Thank you for consulting Historic England in relation to this project.

We note we have been named in EXQ1 in relation to Q11.1.1, Q11.0.3 and Q11.0.6 and have provided responses below.

Heritage Receptors Plan

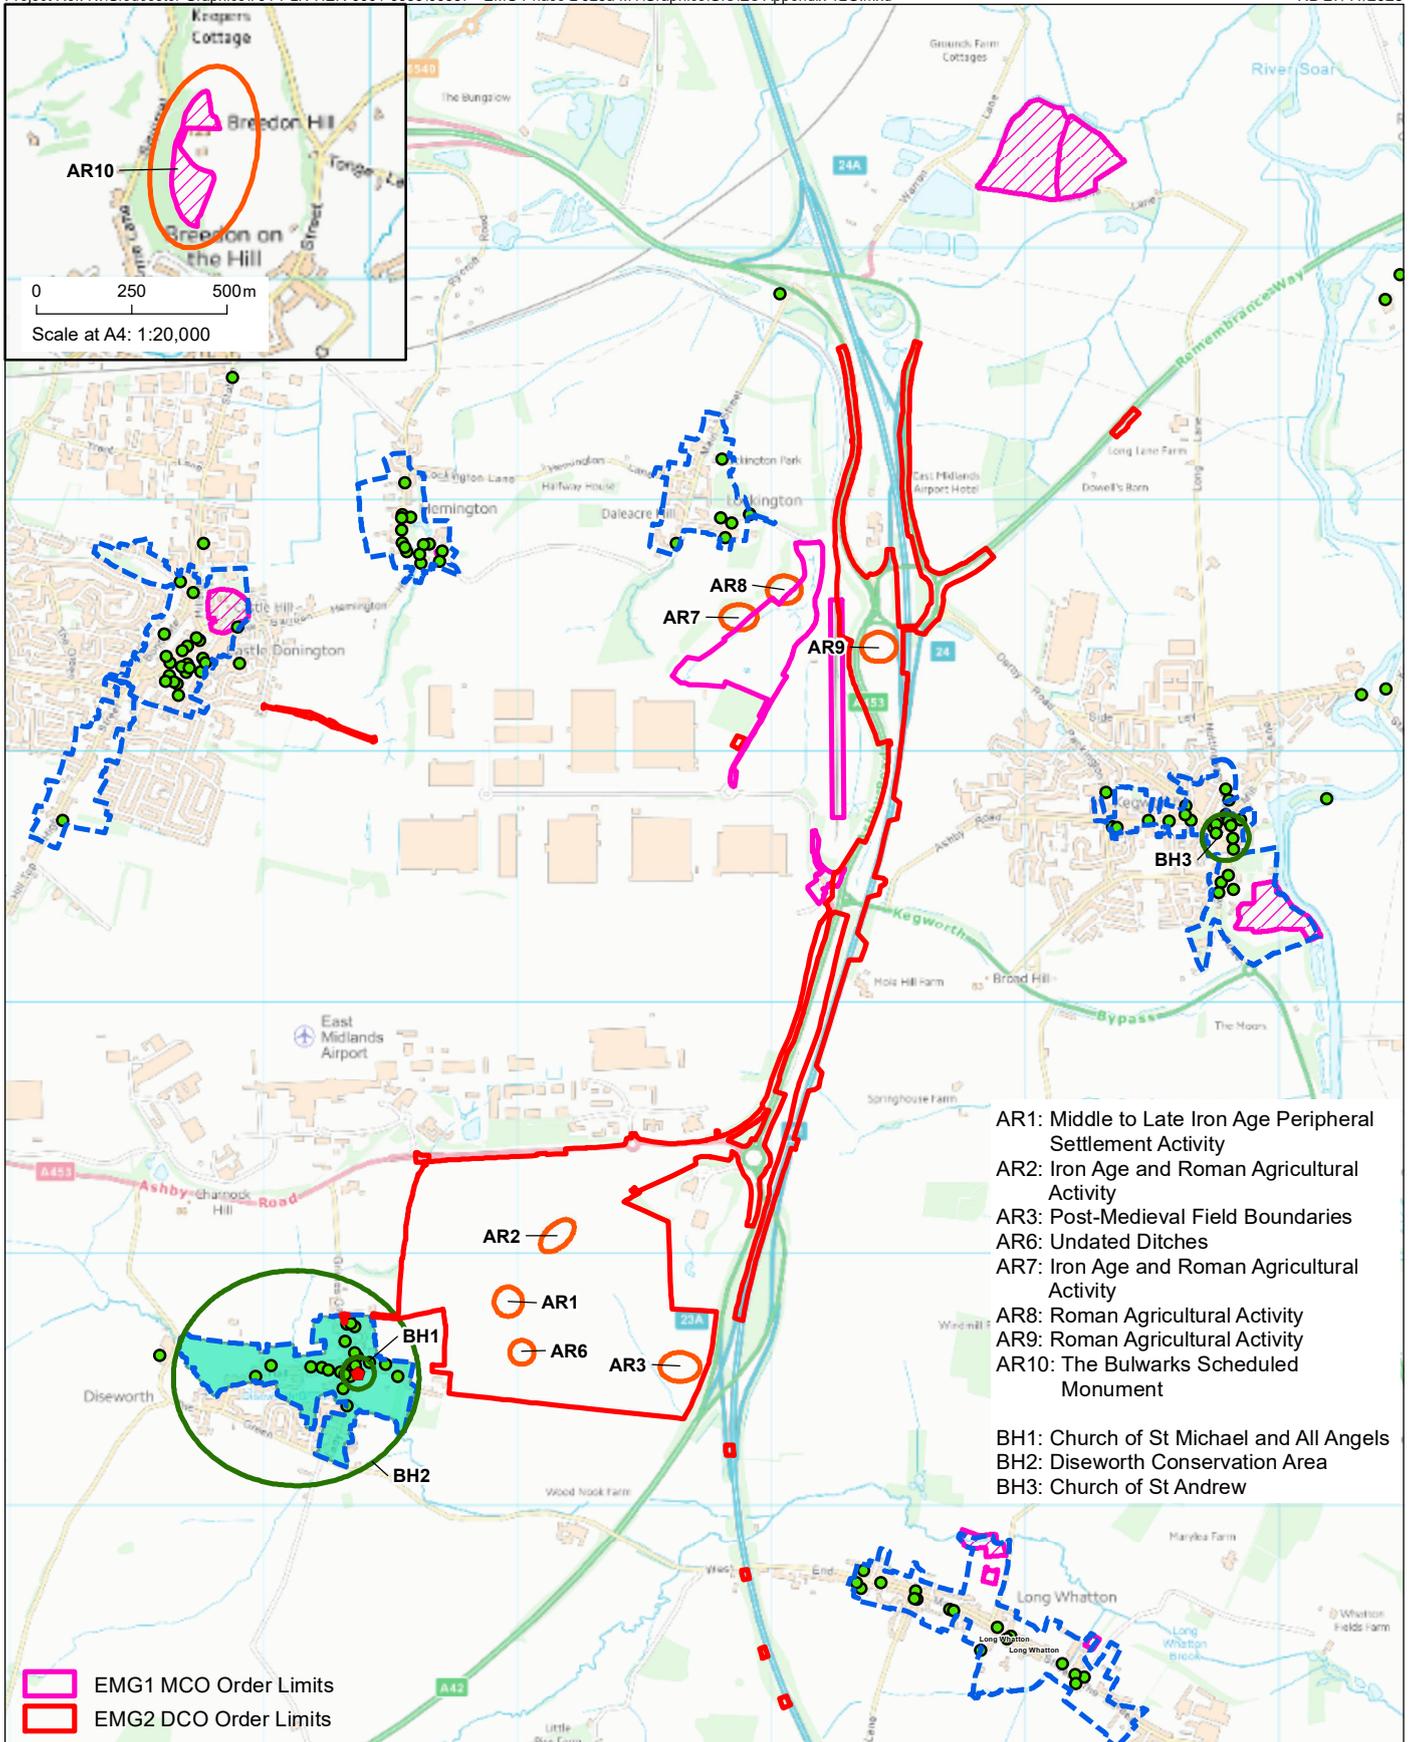
We note the submitted Built Heritage Statement states the 'Built Heritage Statement concludes that the development of the EMG2 Works will likely result in a medium level of less than substantial harm to the significance of the Grade II* listed Church of St Michael and All Angels and a low level of less than substantial harm to the significance of Diseworth Conservation Area'.

We would agree that the closely grained nature of Diseworth conservation area does provide some screening in terms of the assets within it, however, we consider that the holistic experience of the approach from north east on Hynam's Lane to the Conservation Area and its contribution to the significance and character of the Conservation Area should be considered further, further to assessment to our guidance (GPA3) when considering design and mitigation. This should also consider the Church of St Michael and All Angels in the centre of Diseworth, given the applicants own assessment that the 'legibility is mainly signified by the landmark presence of the Church spire'. Impact to the conservation area and the church of St Michael and All Angels should be considered holistically in terms of kinetic experience and their group value.

Regarding St Mary and Hardulph church, the applicant states that the proposal would result in 'no meaningful impact on the asset's significance'. However, we suggest that the experience, through introduction of competition in the skyline would result in harm to significance. The elevated nature of the site, and the long ranging views that are experienced from atop the landscape promontory would be affected. The level of harm may be towards the lower level of less than substantial harm, however it would nevertheless result in harm. The presence of modern infrastructure in the modern landscape does not detract from the level of harm that the asset would experience through further change, and thus should be assessed proportionately.

Overall, we would agree with the assessment of less than substantial harm to both the Diseworth conservation area and St Michael and All Angels Church, but suggest that harm to St Mary and Hardulph church should also be considered further. Where harm falls within the spectrum of less than substantial harm to the identified designated assets' significance, paragraph 215 of the NPPF states harm should be weighed against the public benefits of the proposal.

Whilst there was a historic association between the site and Langley Priory, the site would once have comprised a large

part of the monastic landscape associated with St Mary and St Hardulph Priory Church, Breedon on the Hill (GI listed building and associated hill fort scheduled monument), and Langley Priory (GII* listed building).

Whilst we don't agree with the applicant's conclusion that there is no setting impact, we acknowledge the wider landscape has changed over time. The proposal site makes a very limited contribution to the significance of Langley Priory. In this respect while the proposed development would cause harm to the significance Langley Priory derives from its setting, this would be a negligible level of less than substantial harm.
